2005-0120
Application I. D. Number
6/7/2005
Application Date
Relocation of House
Project Name/Description

17 - 17 Brewer Street, Portland, Maine
Address of Proposed Site
220 B006
Assessor's Reference: Chart-Block-Lot

RE: Application for Single Family House Relocation, Brewer Street, ID # 2005-0120

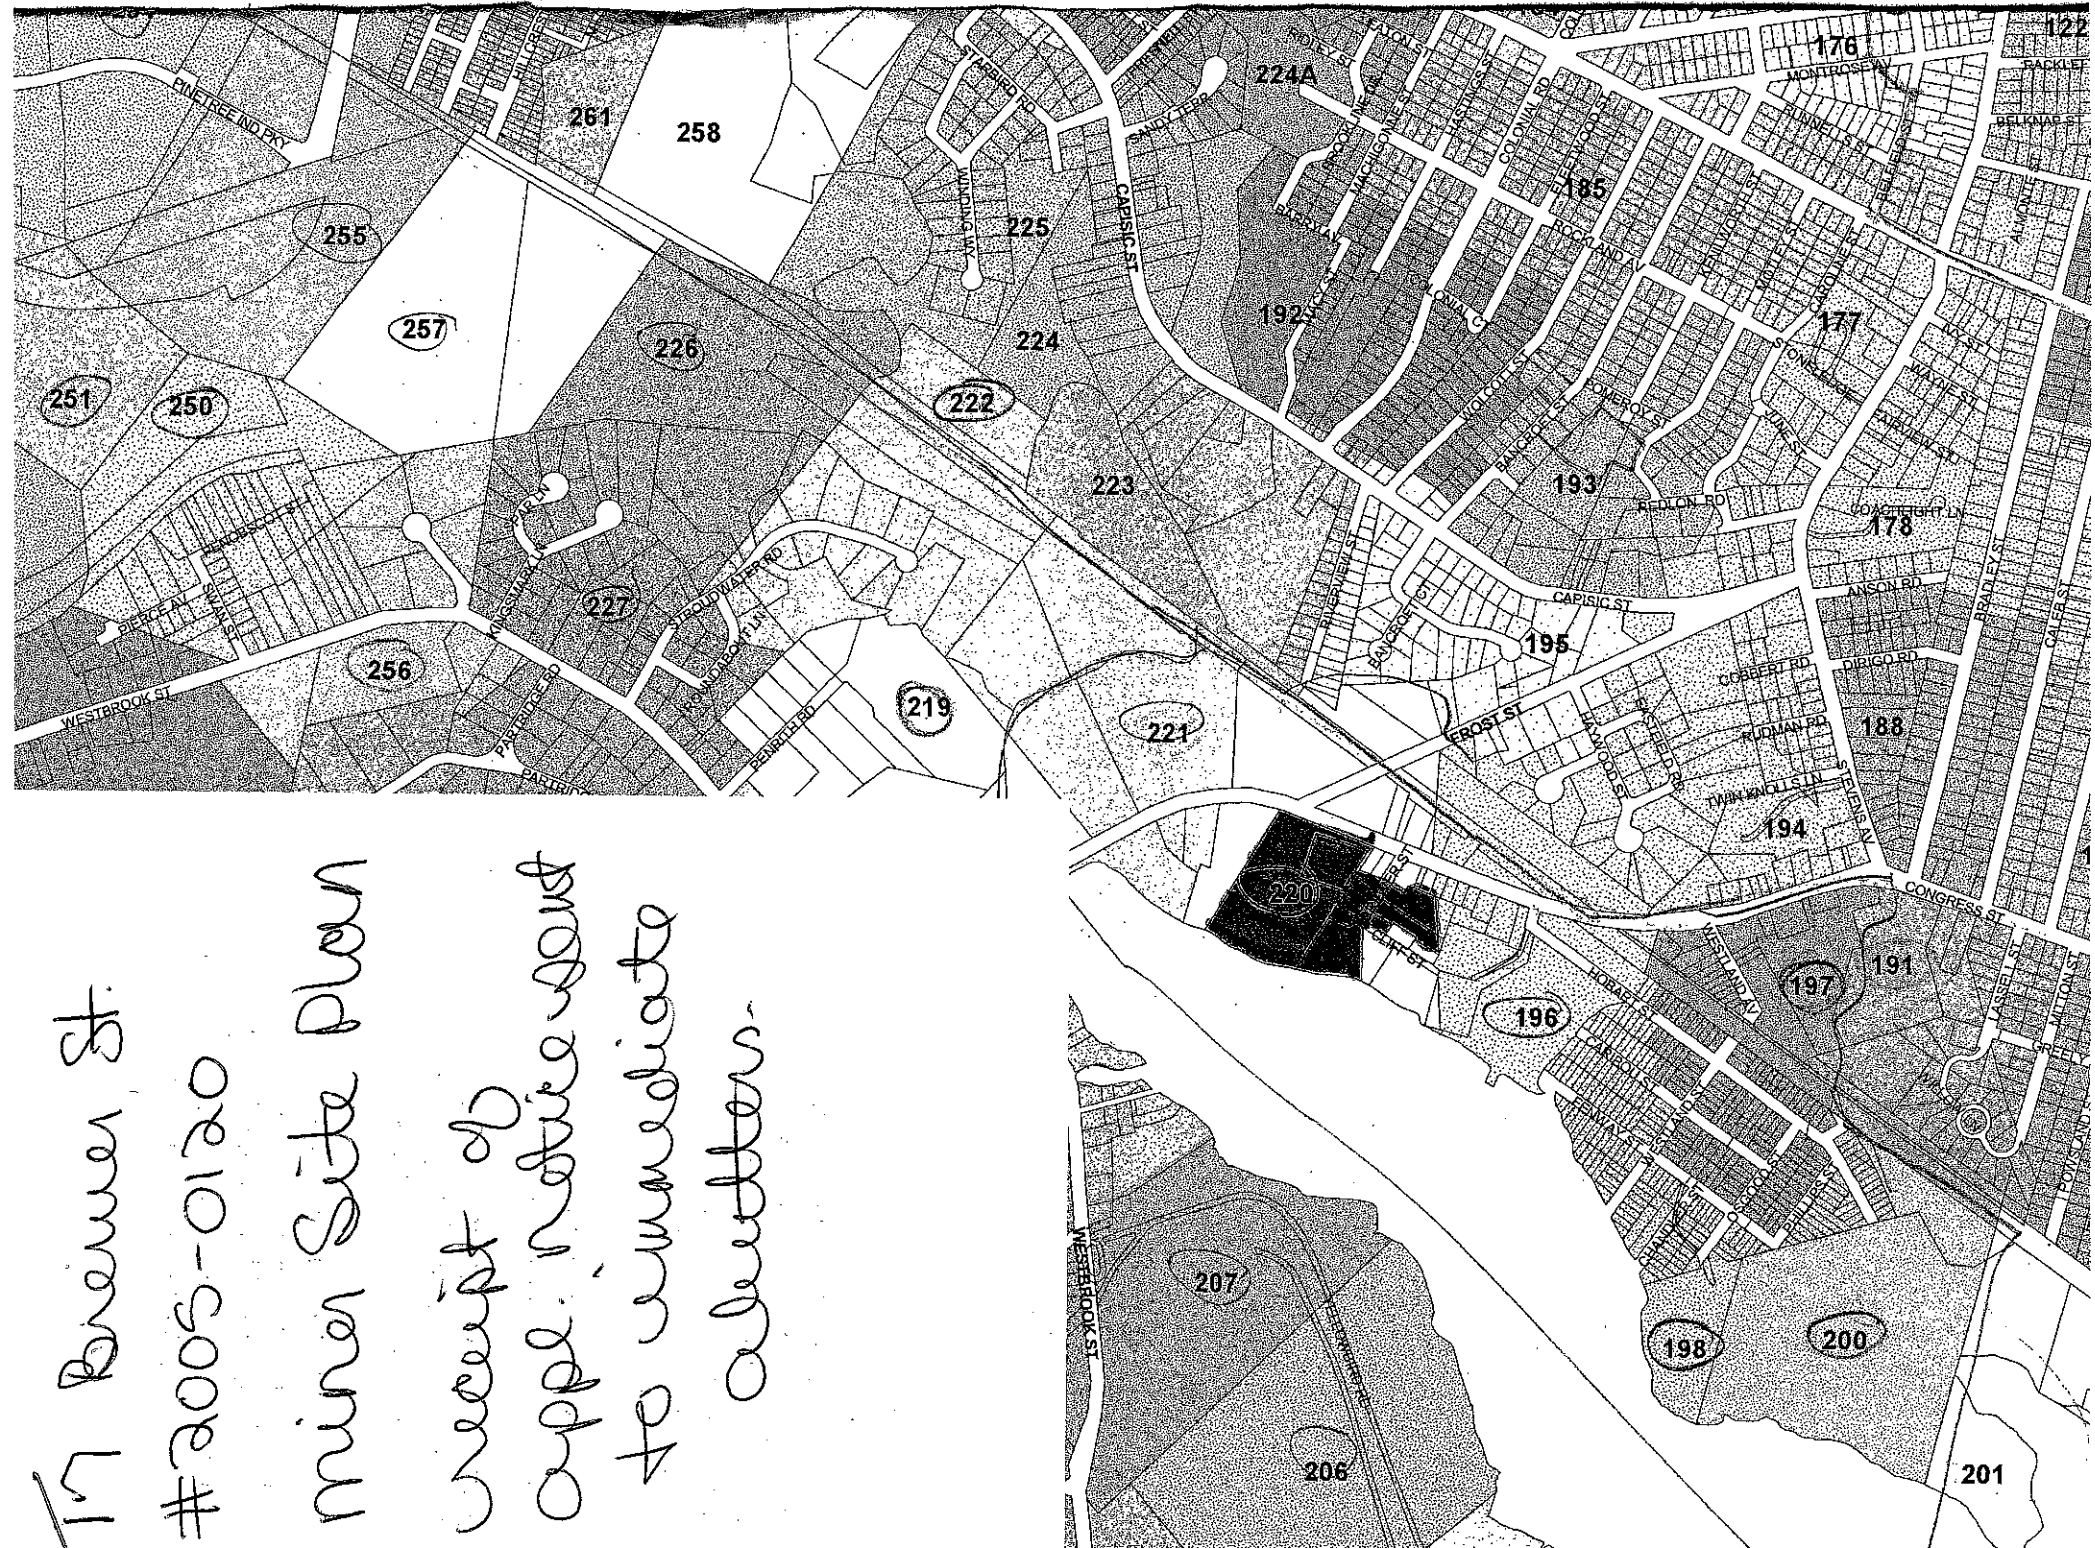
1. 4 parking spaces, 9'x19' each, are required (2 per unit). Please add 4th space to the site plan. Note: parking in the R-5 zone must be outside of the front setback.
2. Relating to item #1, it may be possible to add the 4th space in front of the garage and eliminate the proposed curb cut and paved driveway in front of the new building. Please consider.
3. Please show proposed topography/grading on your site plan.
4. Add erosion control (silt fence) as applicable.
